Ribble Valley Borough Council
Housing & Development Control

Application no: **3/2019/0514**

Address: **Little Woodfield Farm Longsight Road Clayton le Dale BB2 7JA**

Proposal: **Conversion of barn to dwelling and rebuilding attached garage**

TITLE.
SITE PLANS AND LOCATION PLAN.

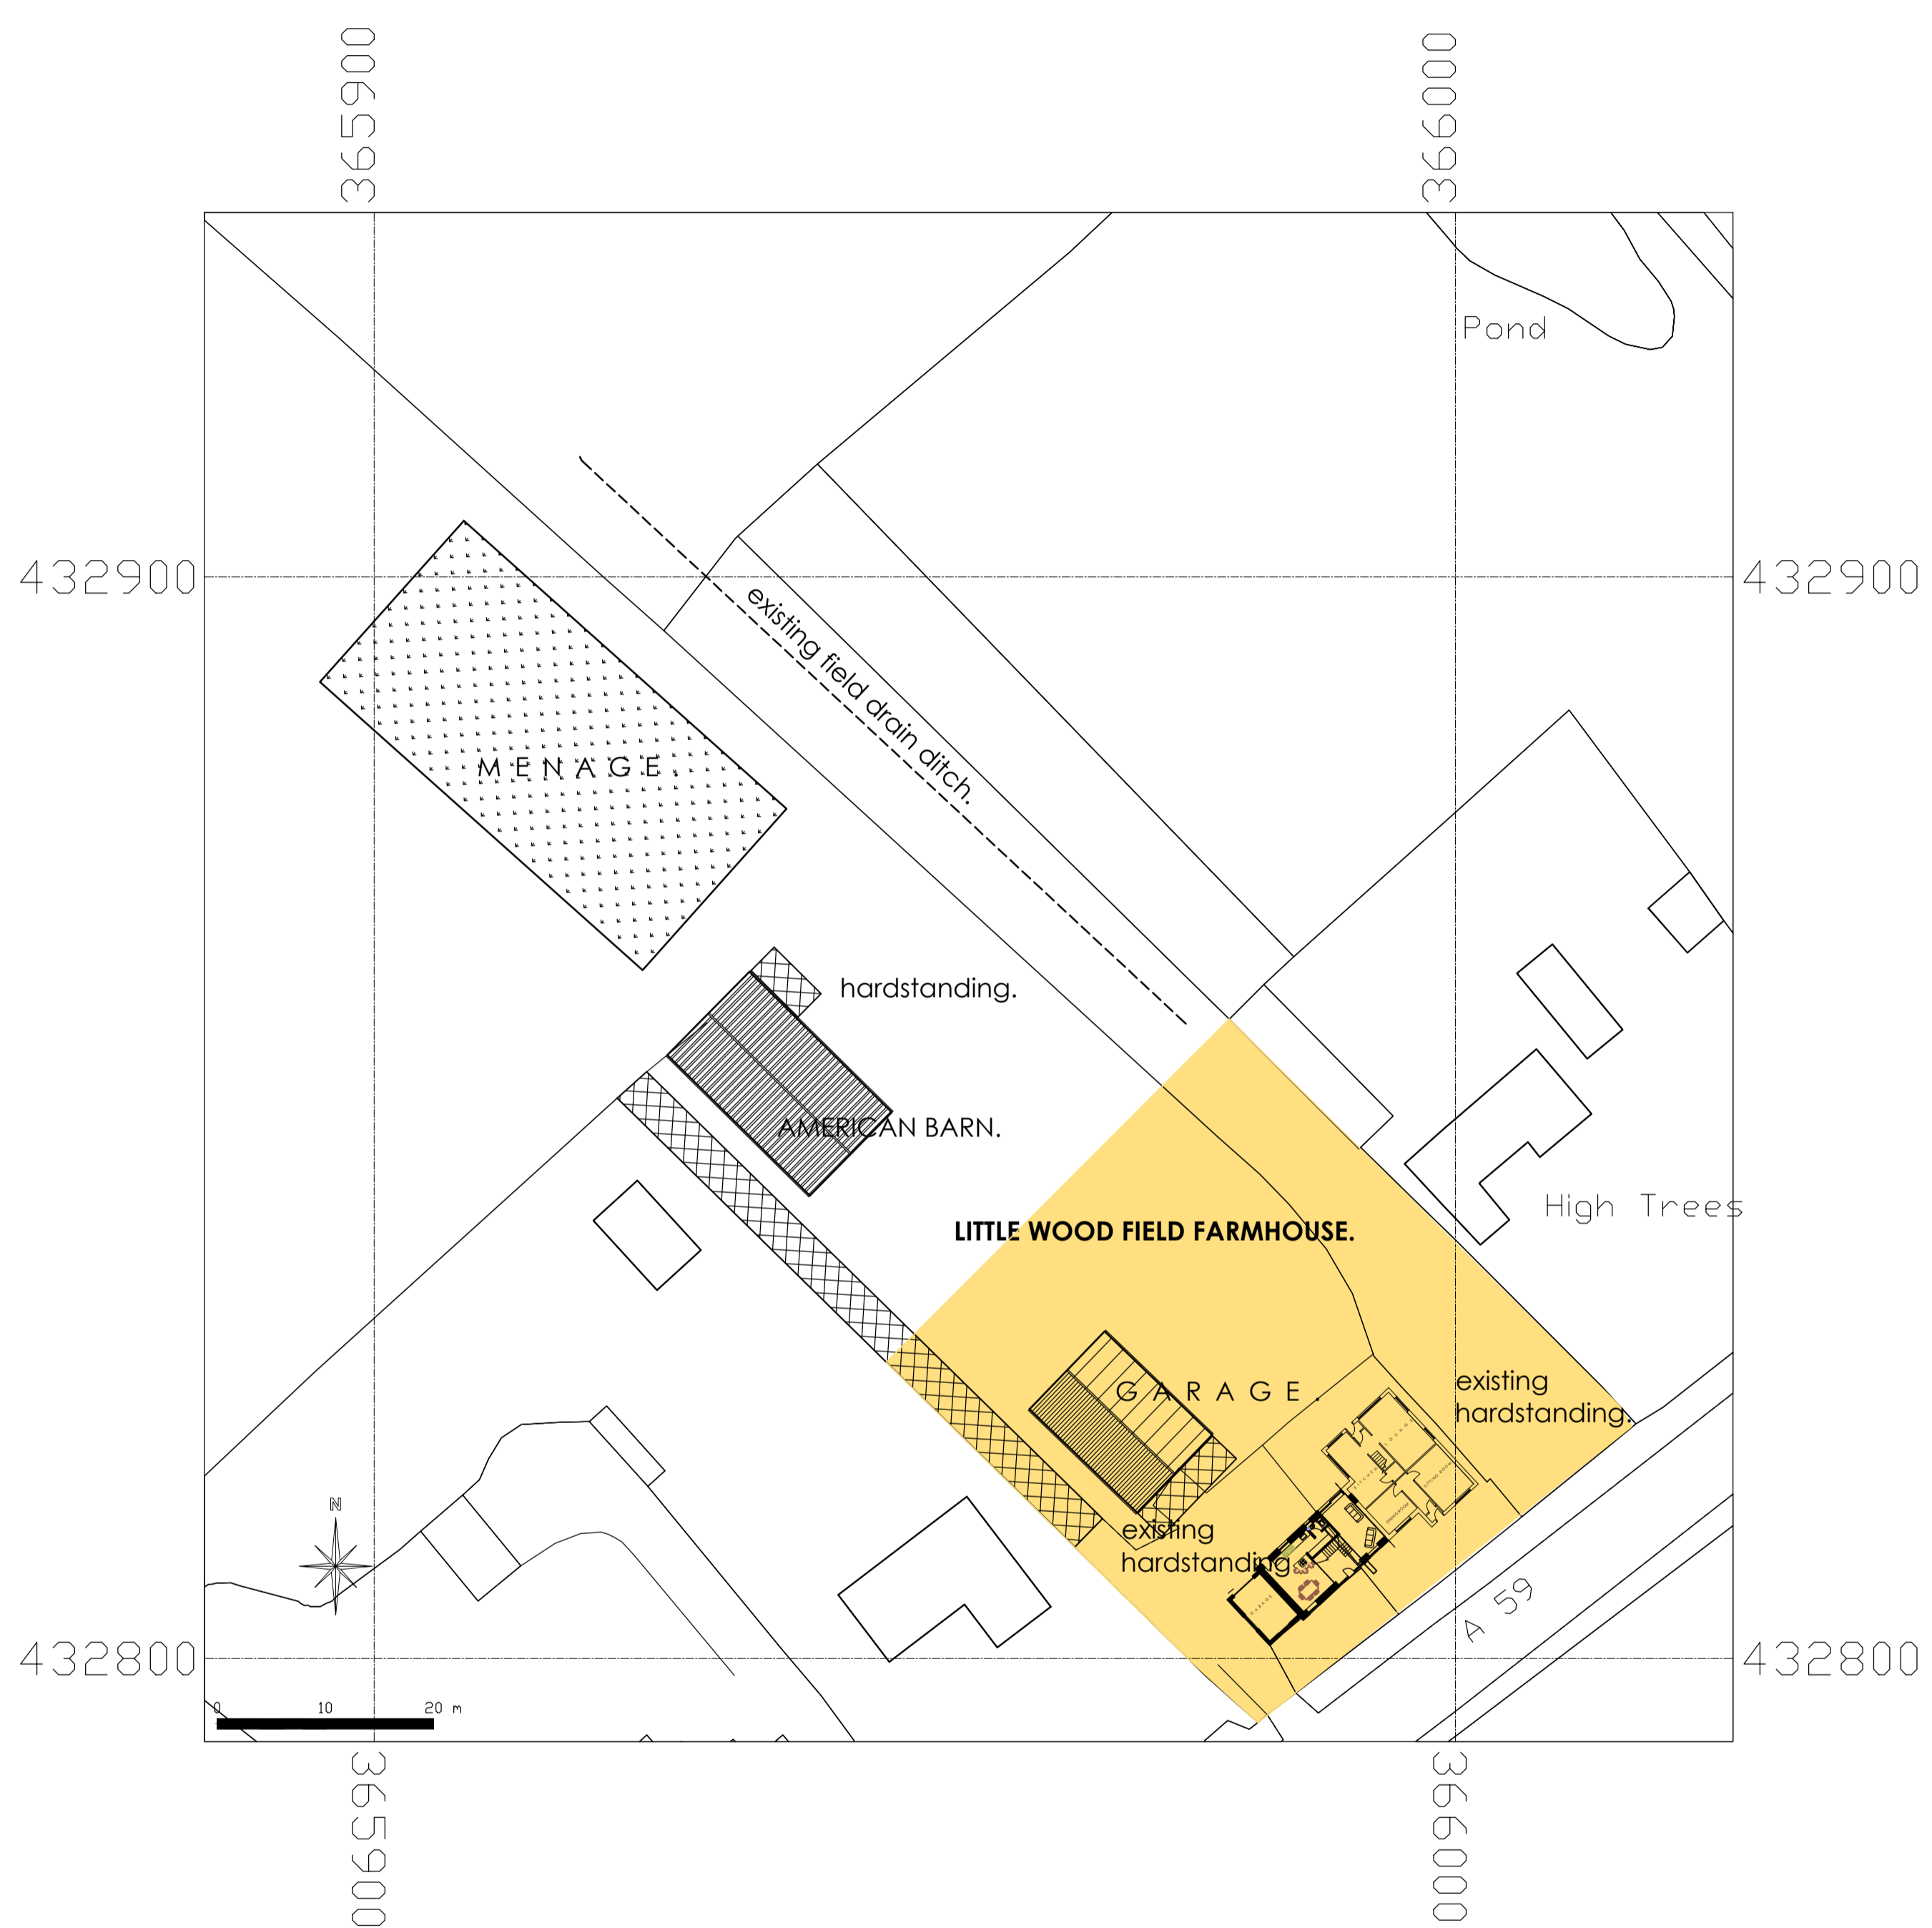
There are two vehicle access points being utilised as part of the planning application.

There is an access point to the North east of the application site which provides access to the existing dwelling, parking area with turning space and field beyond.

The proposed dwelling is to be accessed via the access point to the South west of the application site which also provides access to an existing parking and turning area and the recently constructed garage at the rear of the property. This access also leads to the recently constructed stables, ménage and field beyond.

However, when considering the different types of vehicular traffic which is proposed to utilise the access point at the South west of the application site. For example any horse boxes or other HGV type vehicles the Local Highway Authority will require a swept path analysis being undertaken at this access point.

After attending a site visit on 3rd July 2019 it must be noted that the access point to the North east of the application site has not been bound with an approved surface material.

The submitted application form states there will be no changes to the existing parking provision, where it is proposed that 6 parking spaces will be required in support of the proposal. However, when considering the design and access statement states that the proposed access point provides access to an existing parking and turning area, along with an existing garage that retains six parking spaces alone and a proposed garage which will provide a further one parking space and an existing two parking spaces being retained by the existing dwelling. This all leads to an over intensification of use and clarity is sought behind the reasoning for this.

There is also a requirement for the parking of horseboxes and any potential heavy goods vehicles and agricultural machinery associated with the agricultural upkeep and maintenance of the land. Although there is sufficient space within the curtilage of the ownership boundary to support this.

I ask the plans be revised.
